From: [REDACTED]
Sent: 16 September 2021 11:17
To: Simon Davis
Subject: Fwd: Planning Consultation on: P/119/21/DOC - drainage issue and amended drawings attached.
Attachments: D1966-400 Private Construction Details Sht 1.pdf; D1966-103.1 RevC Proposed Drainage Sht 1.pdf
Categories: For future upload

As requested by the ADC drainage officer, our consultants have amended the drawings accordingly. Please find attached.

Apologies - I've never been asked for this before, but I've obtained the below accordingly. I've added it to the drawing and detail as requested also, please forward the attached.

FLOW CONTROL CHAMBER
(Scale 1:20)

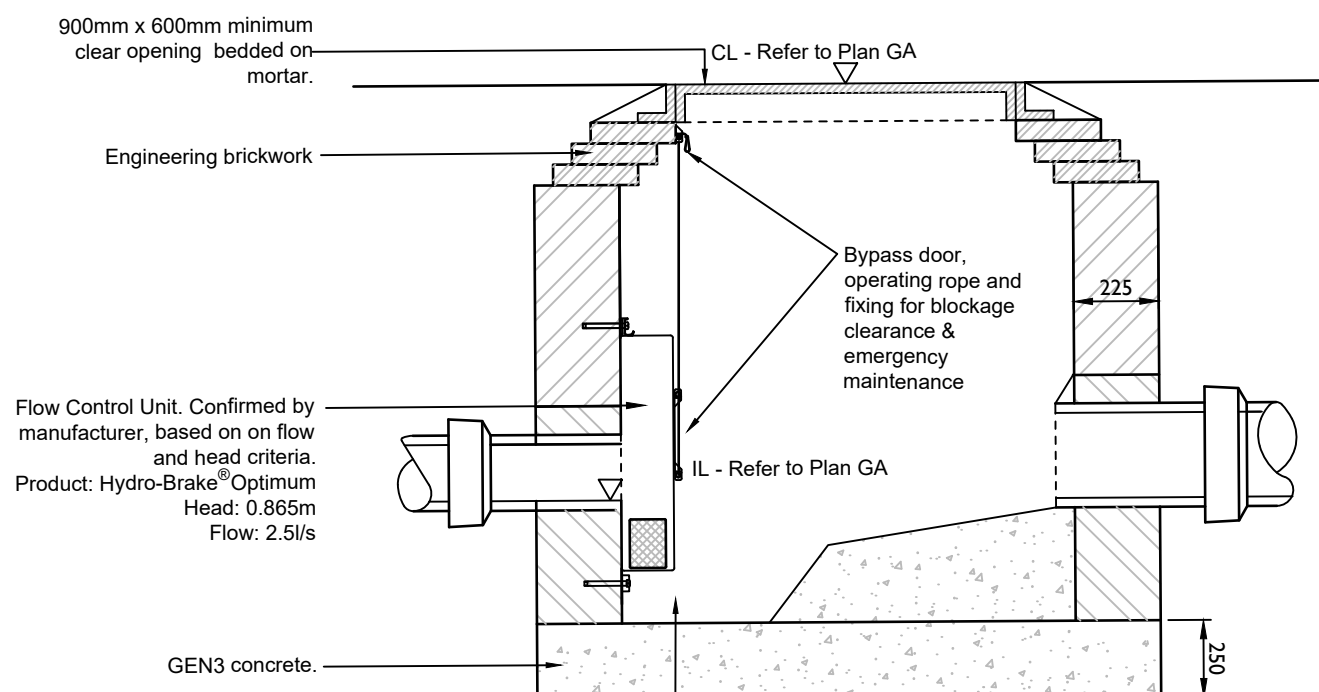
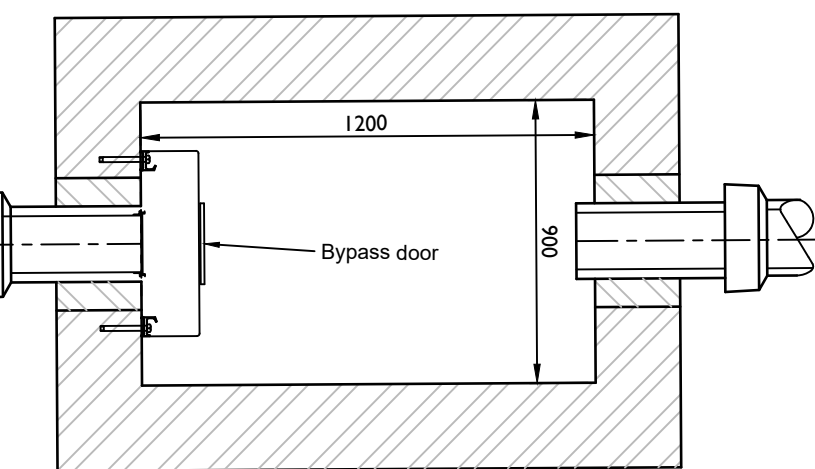
Product: Hydro-Brake Optimum

Product Reference Number: CTL-SHE-0077-2500-0865-2500

Dimensions W x D (mm) : 410 x 85

Sump Dimensions W x D (mm) : 170 x 310
